TOWN AND COUNTRY PLANNING ACT 1990

OUTLINE

Reference:	H11-0957-18	Date of Decision:	19th September 2019
Applicant:	Mr Matthew Footitt 66 Church View Northborough Peterborough Cambs PE6 9DQ		
Location:	84 Roman Bank Long Sutton Spalding		
Description:	Residential development- erection of 3 bed, two-storey dwelling with off road parking

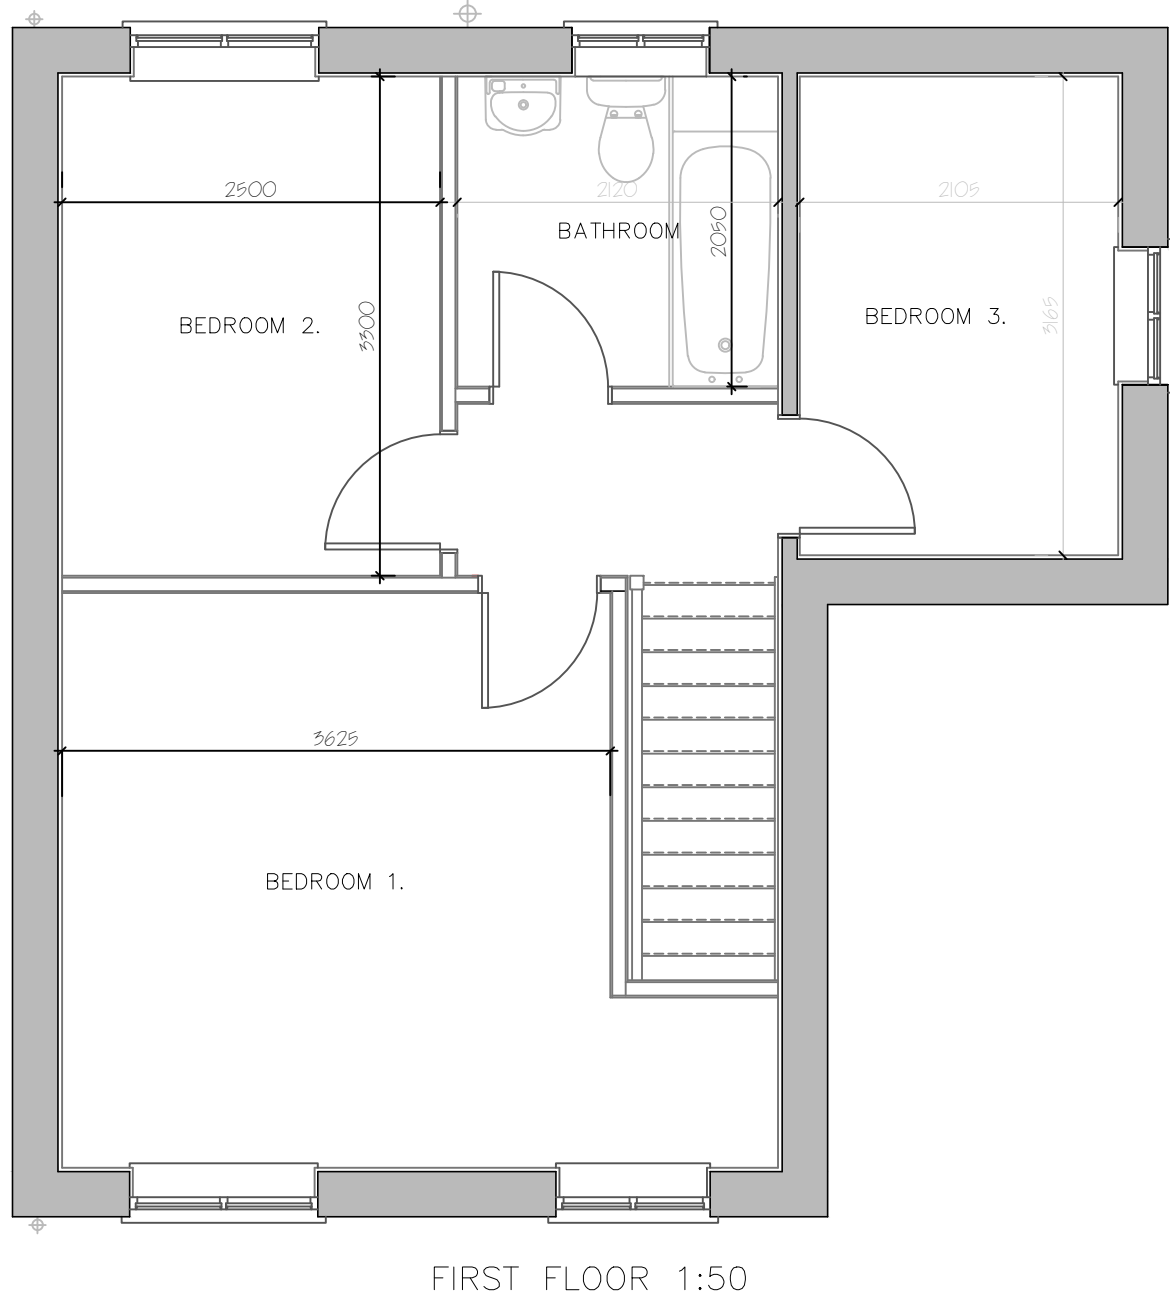
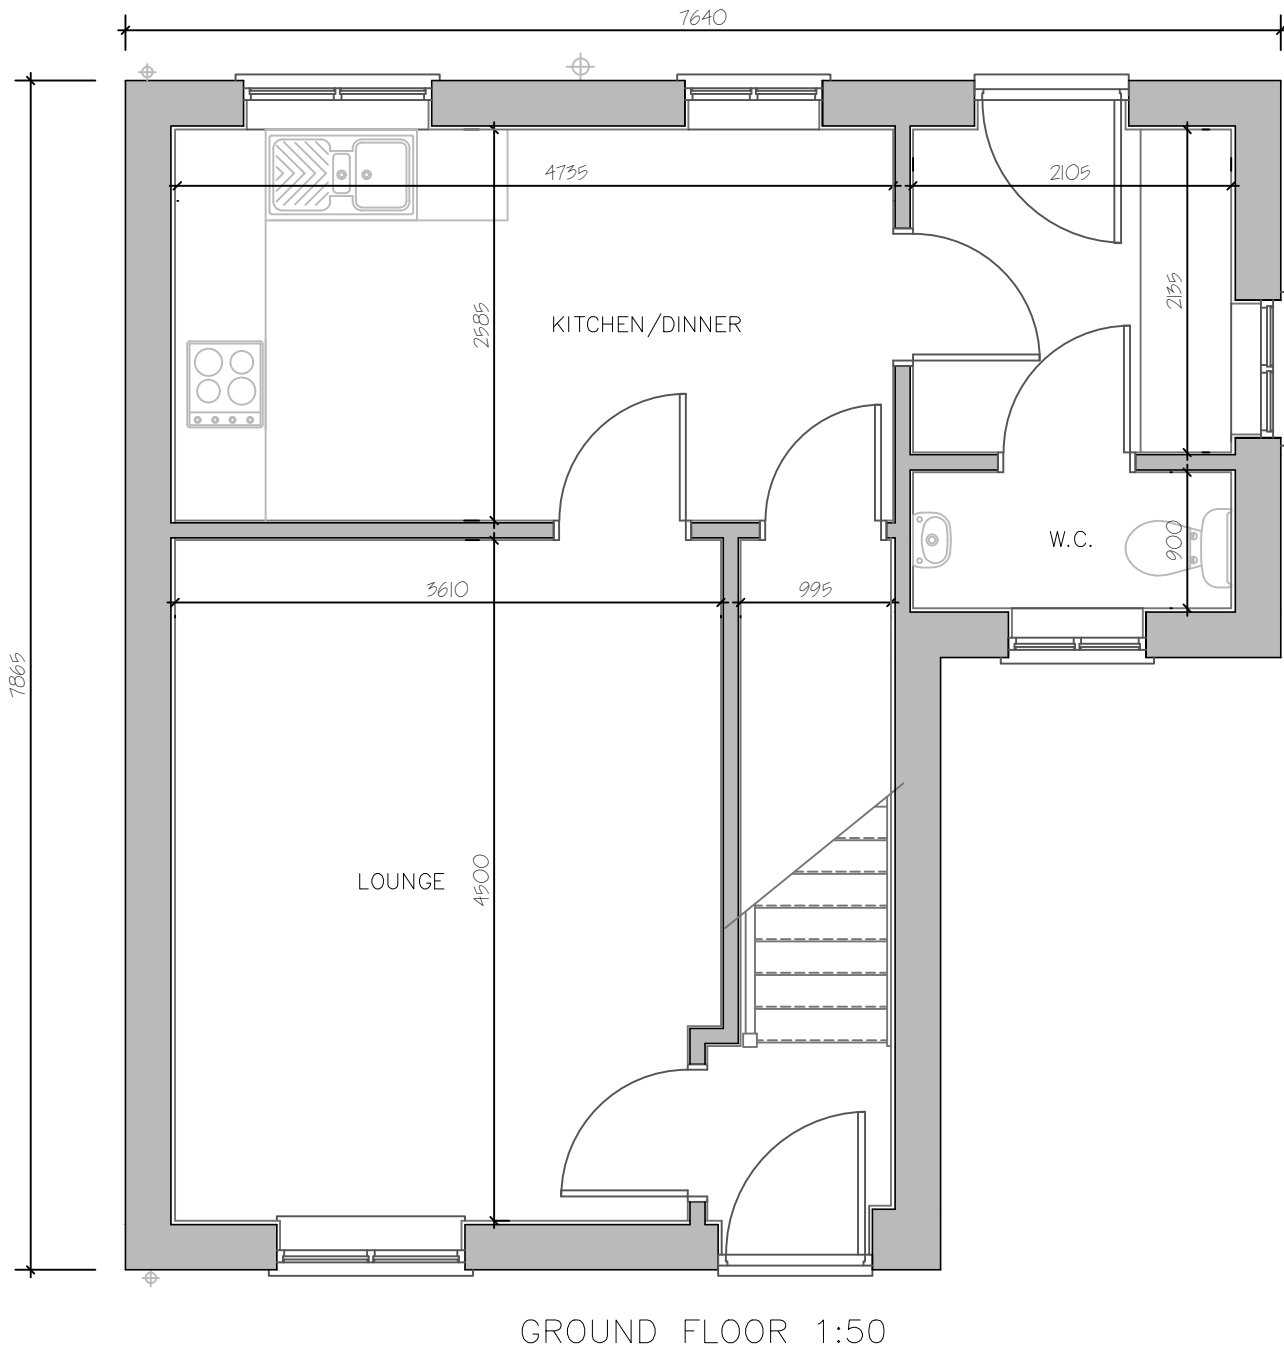
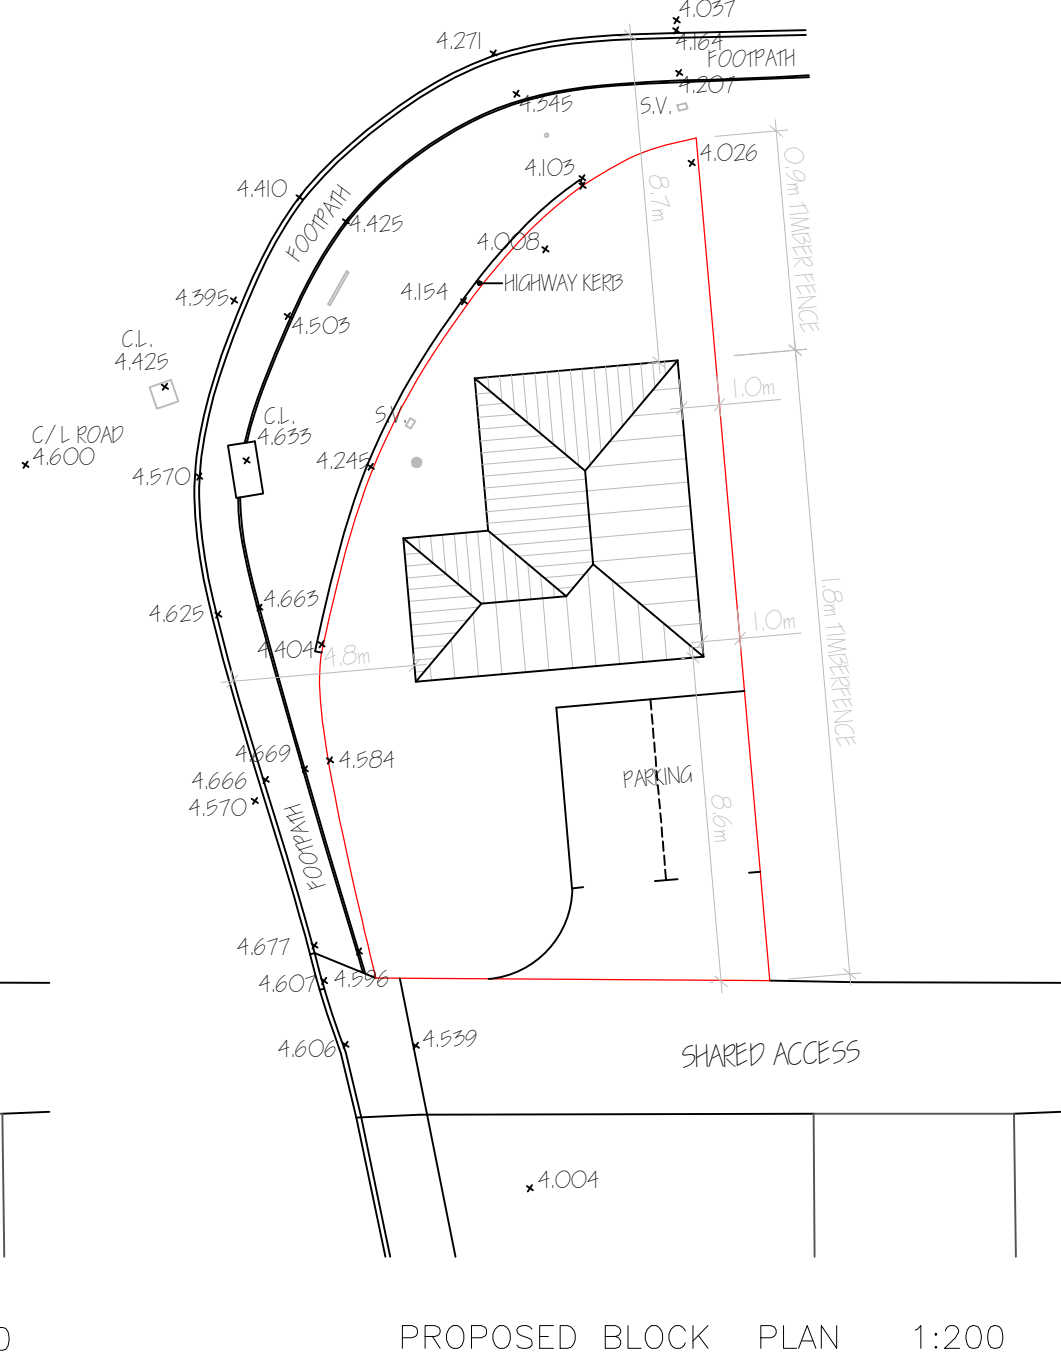
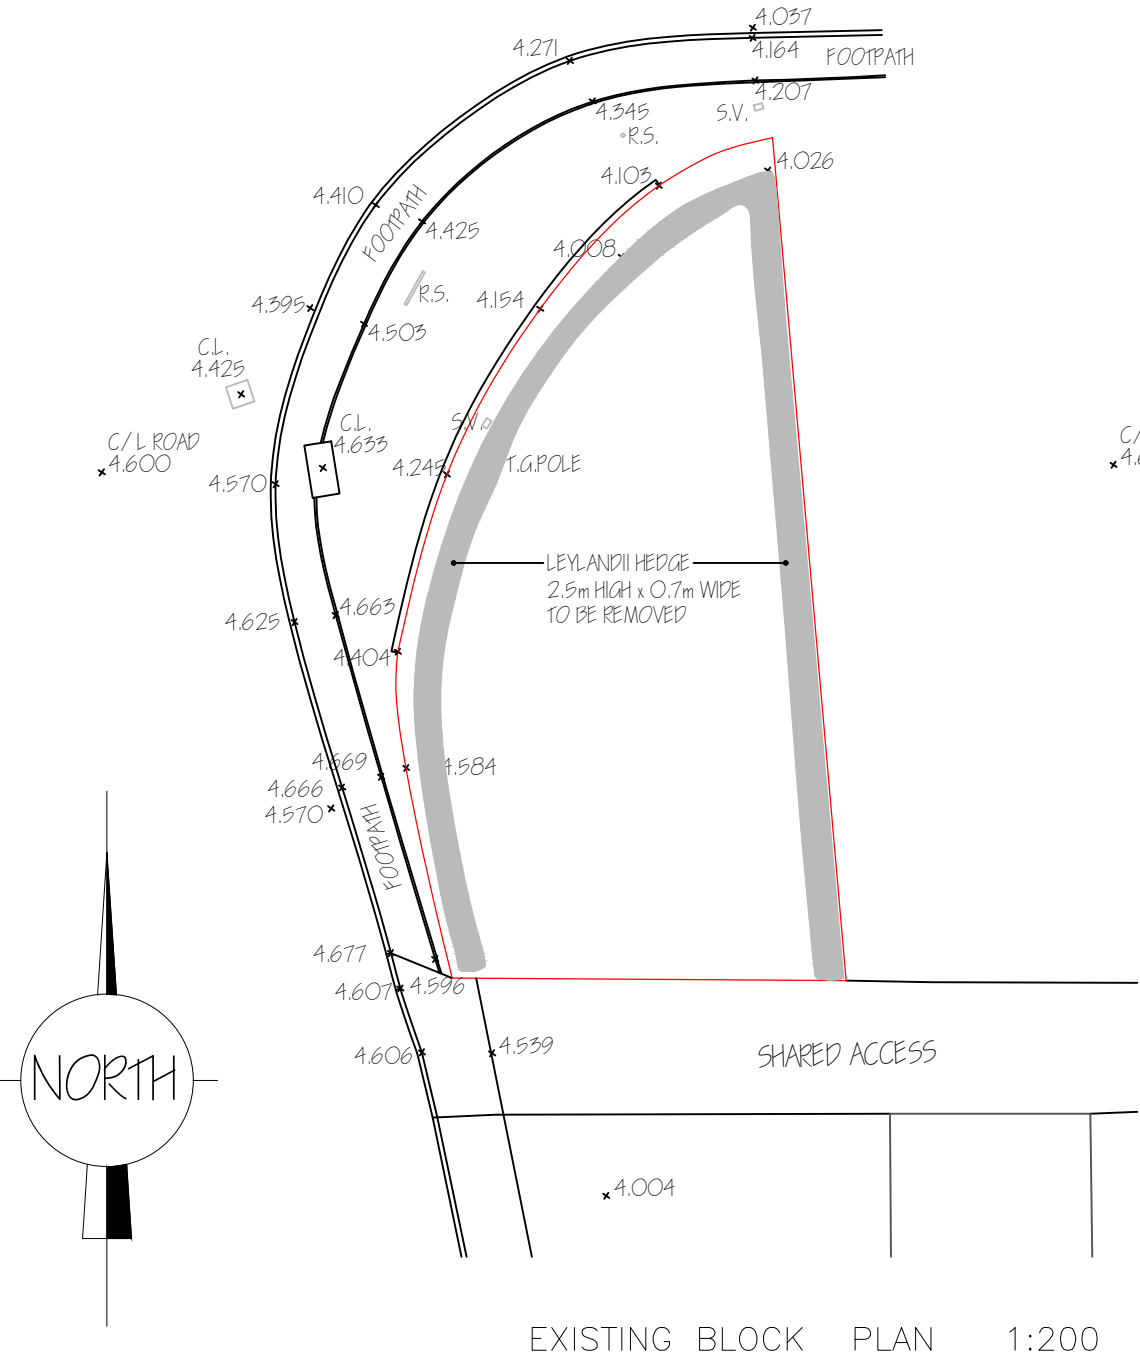
- 1 The site is situated in a prominent location on the corner of Roman Bank and Woad Lane and any dwelling would be sited further forward than 84 Roman Bank. Given the size and positioning of the site, any dwelling would appear incongruous and cramped and would be at odds with the pattern of existing development nearby, which is dwellings generally set within larger plots. Furthermore, a detached two-storey dwelling would be at odds with the character of dwellings within closest proximity to the site (immediately to the east on Woad Lane and south on Roman Bank), which are terraced and semi-detached dwellings.

- 2 Having regard to the likely scale (two-storey) and cramped form of the proposed development and relationship to adjacent dwellings, it is considered that the proposed dwelling would be overbearing in nature for existing neighbouring dwellings.

- 3 The submitted flood risk assessment recommends that finished floor levels should be set at 150mm above existing ground level. However, the South East Lincolnshire Strategic Flood Risk Assessment (2017), in conjunction with the Standing Advice Matrix (2016), indicates that finished floor levels should be set at 300mm above existing ground level.
